A303 Amesbury to Berwick Down

**8.3(1) - Statement of Common Ground – Historic Buildings
and Monuments Commission for England**

August 2019

STATEMENT OF COMMON GROUND – Historic Buildings and Monuments Commission for England

PROPOSED BORED TUNNEL - (WORK No. 1F)

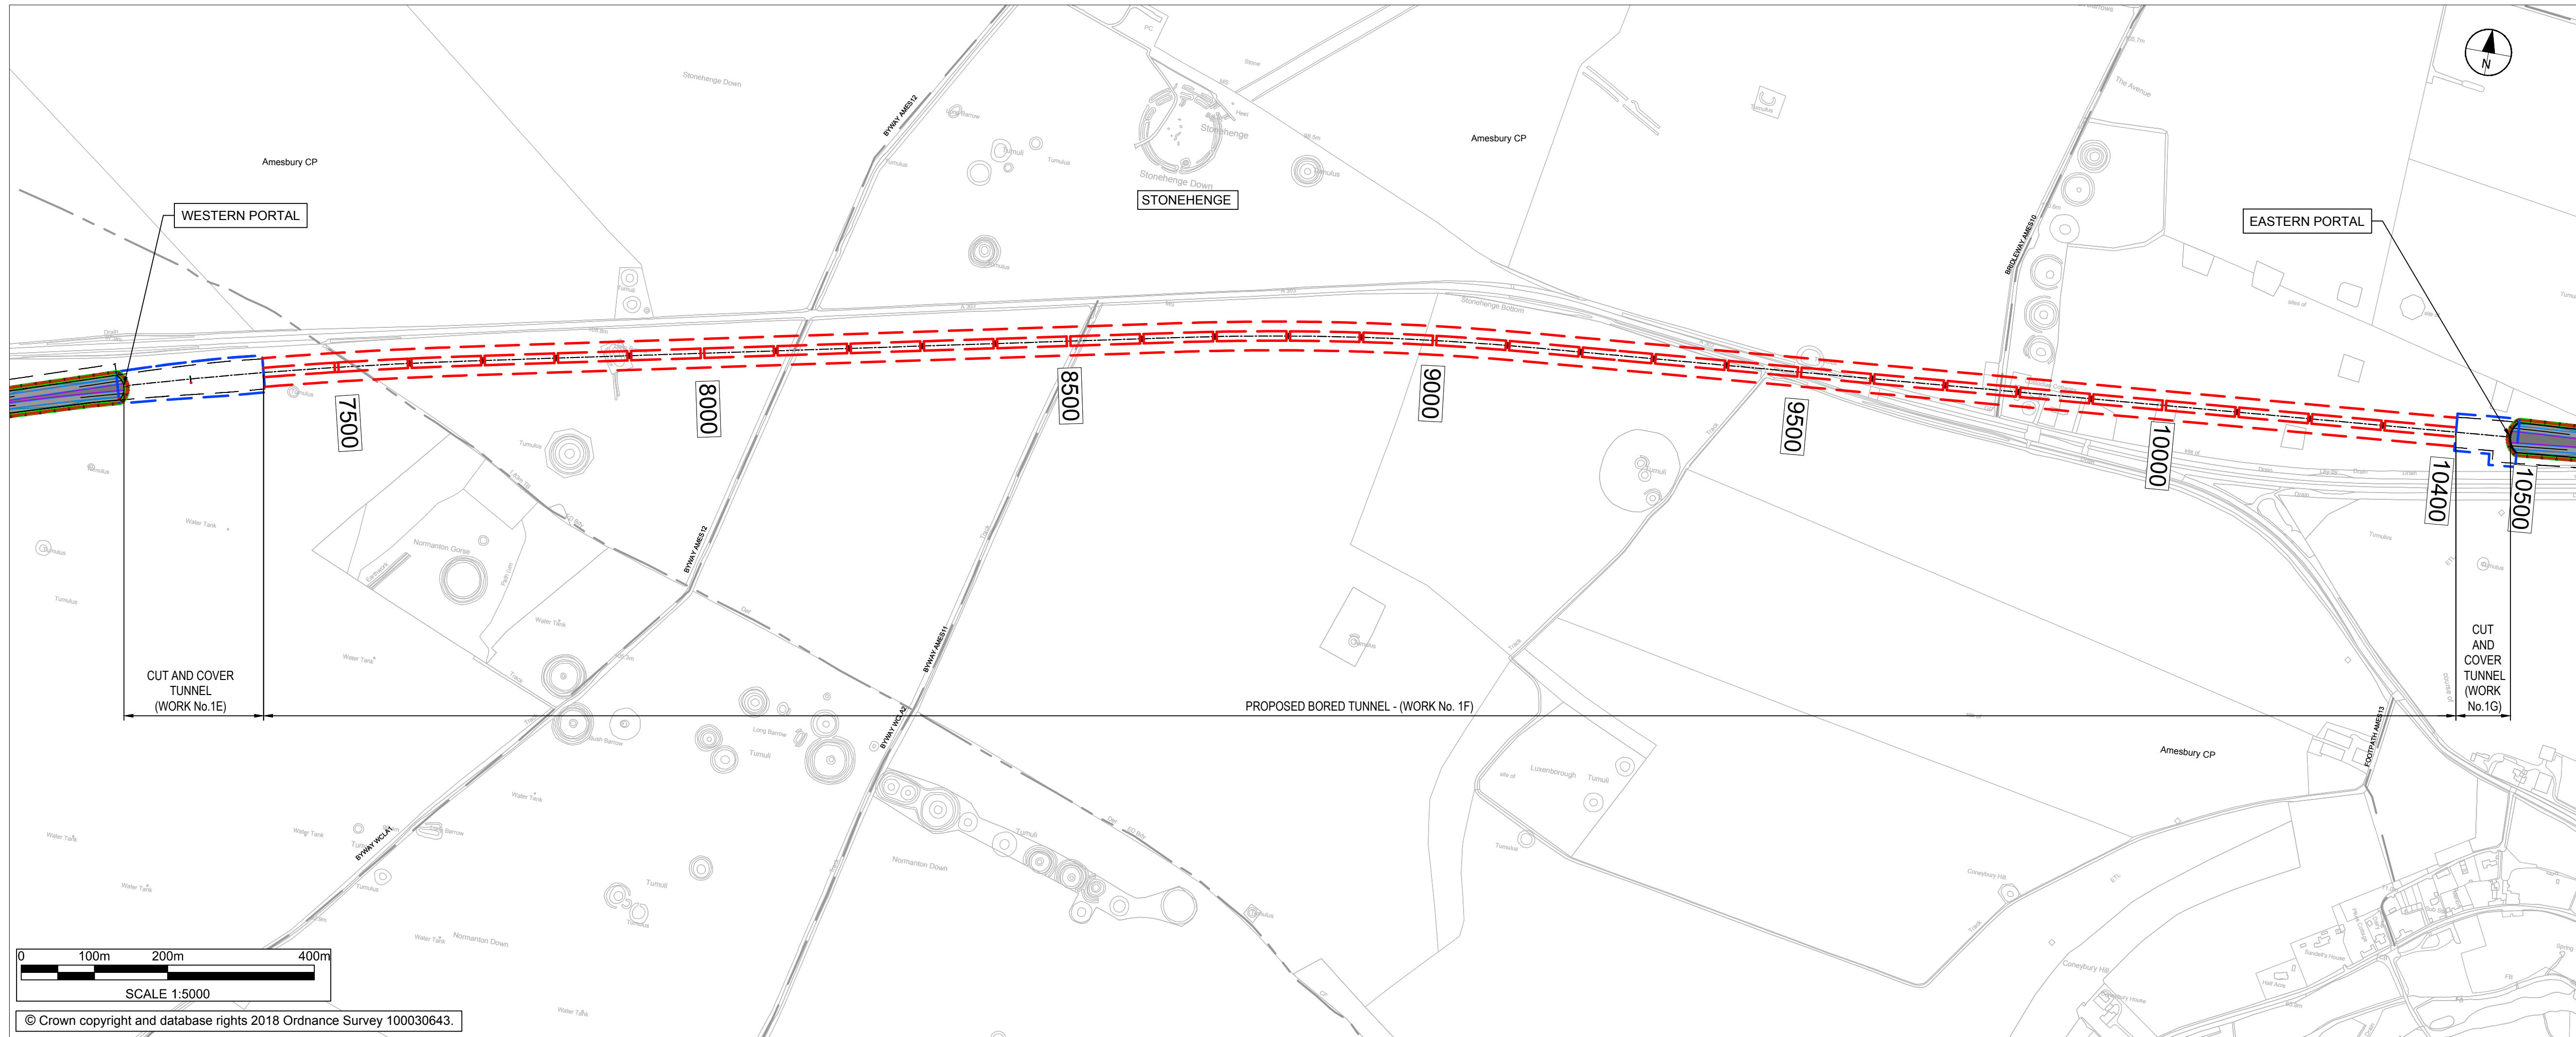
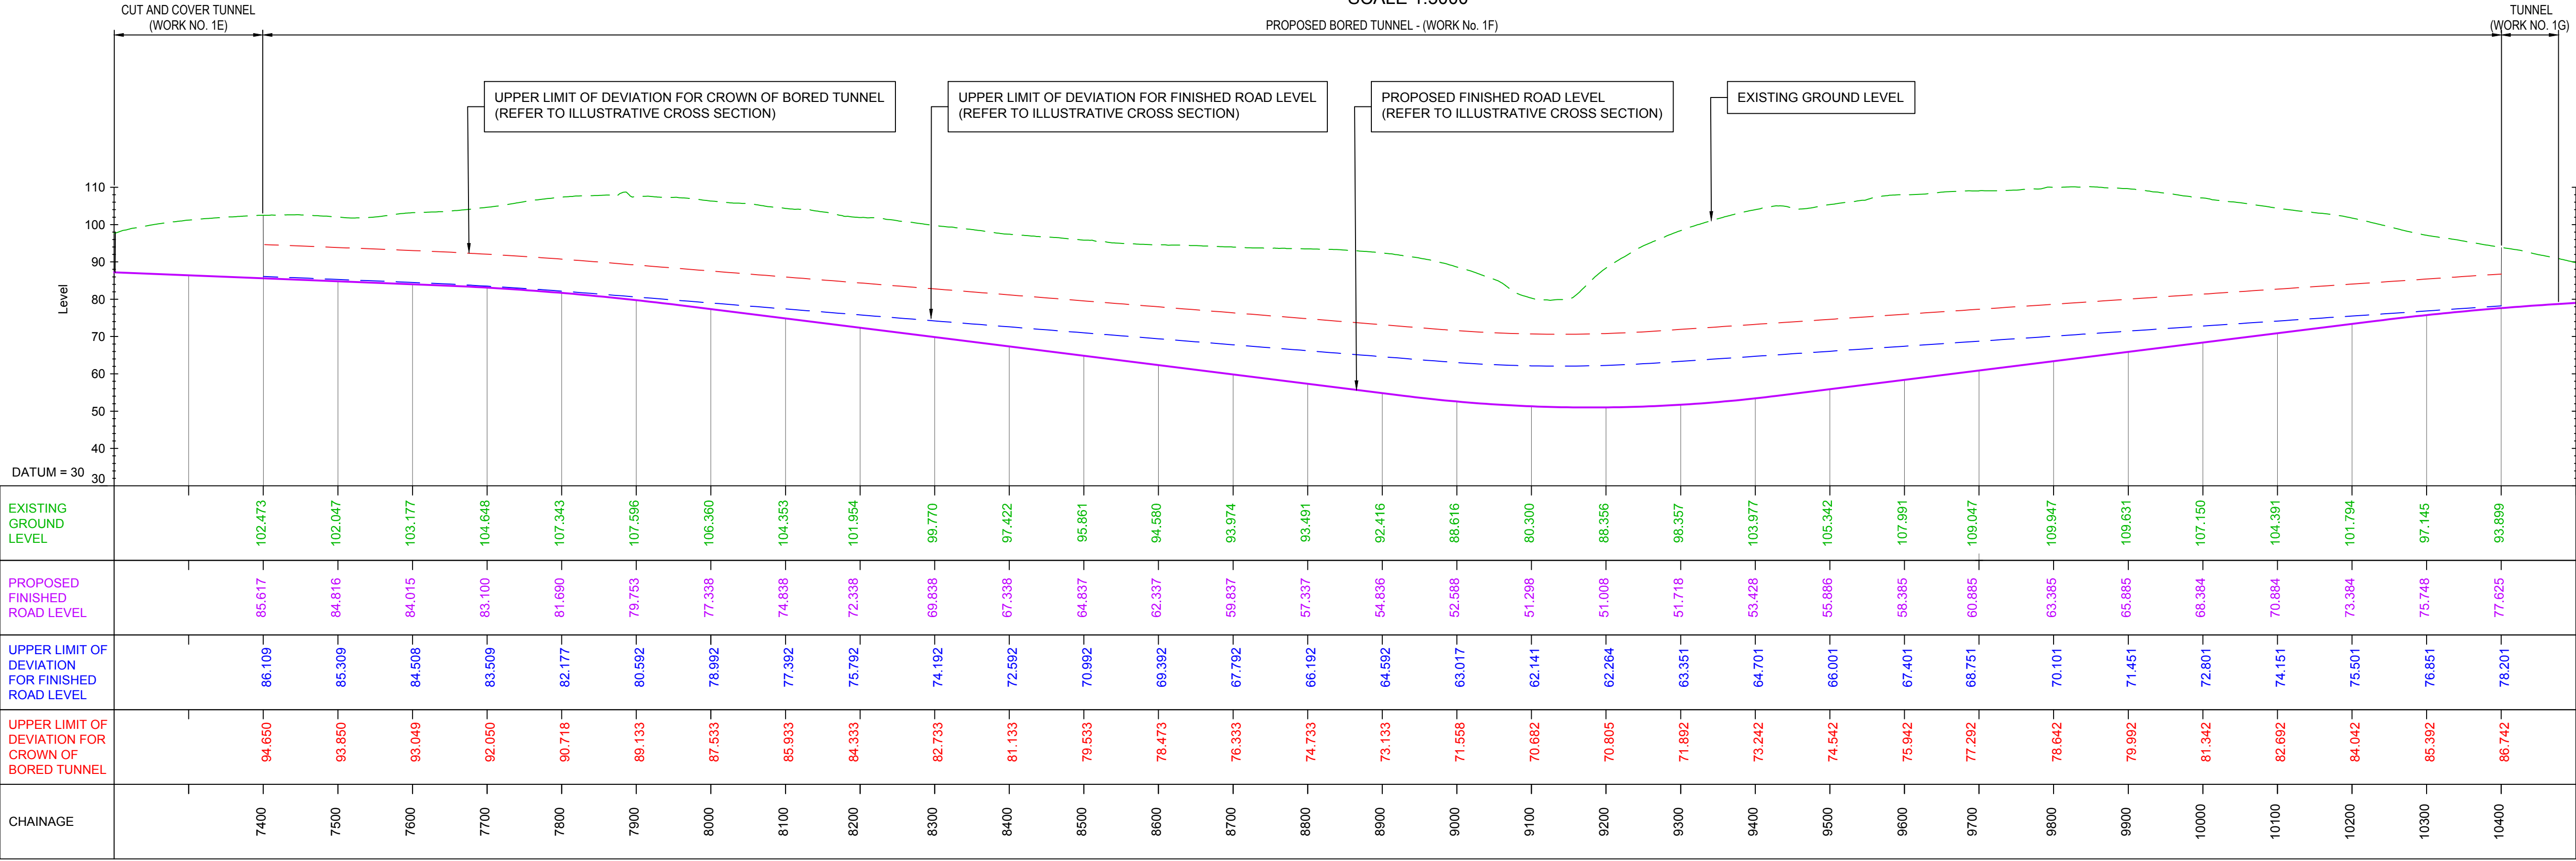
<p>Current Position</p>	<p>Page 7</p>	<p>Paragraph 1.13(k)</p>	<p>greater degree of precision is needed in relation to the actual positioning of the tunnel portals given the sensitivity of the landscape. HBMCE considers the limits of lateral deviation westwards in the first draft DCO of 200m for the western portal to be unjustified at this point.</p> <p>HMBCE stated in the Summary of Written Representations [REP2-101] that detail is needed (e.g. in relation to vertical limits of deviation for the tunnel), together with consideration of a parameters framework, to ensure that there is no restriction to potential future archaeological work above or below ground level but above the tunnel crown level identified in the first draft DCO. This would be contrary to Article 4 of the 1972 Convention and the policies of the SAAS WHS Management Plan.</p> <p>The lack of design details relating to some elements of the Scheme does not provide clarity over the impacts the deviations could have. We remain in discussion so that Highways England can provide clarification of these impacts through visualisations or written details.</p>	<p>of the first drive, the TBM will be received within the temporary portal where it will be turned around and re-launched to drive the second bore east to west. Therefore, the location of the drive and reception portals is a very important consideration as part of overall safe tunnel construction and operation of the TBM and flexibility is sought to facilitate this in tunnelling.</p> <p>TBMs are large and complex machines; the cutting head and segment erector are contained within the shield and constitute the main components at the front of the TBM and are followed by a long train of supporting ancillary trailers supplying all the mechanical and electrical equipment, pre- cast segments and other materials in addition to the means of removing the excavated material. Making an adjustment to either the vertical or horizontal alignment of the tunnel can only be accommodated by a series of small incremental adjustments during the construction of each individual ring within the front shield. Therefore, any change in the alignment for a large diameter TBM can take between 200-300m to accommodate during tunnelling. This is why the 200m westerly deviation is sought at the western portal.</p>

<p>The document 8.31 - Comments on the DAMS and on any further information requested by the ExA and received to Deadline 3 – explains limits of deviation in further detail at page 13-122.</p> <p>The extent to which the 200m westwards LoD is used will be determined during detailed design and their full exercise has been assessed in the Environmental Statement.</p>
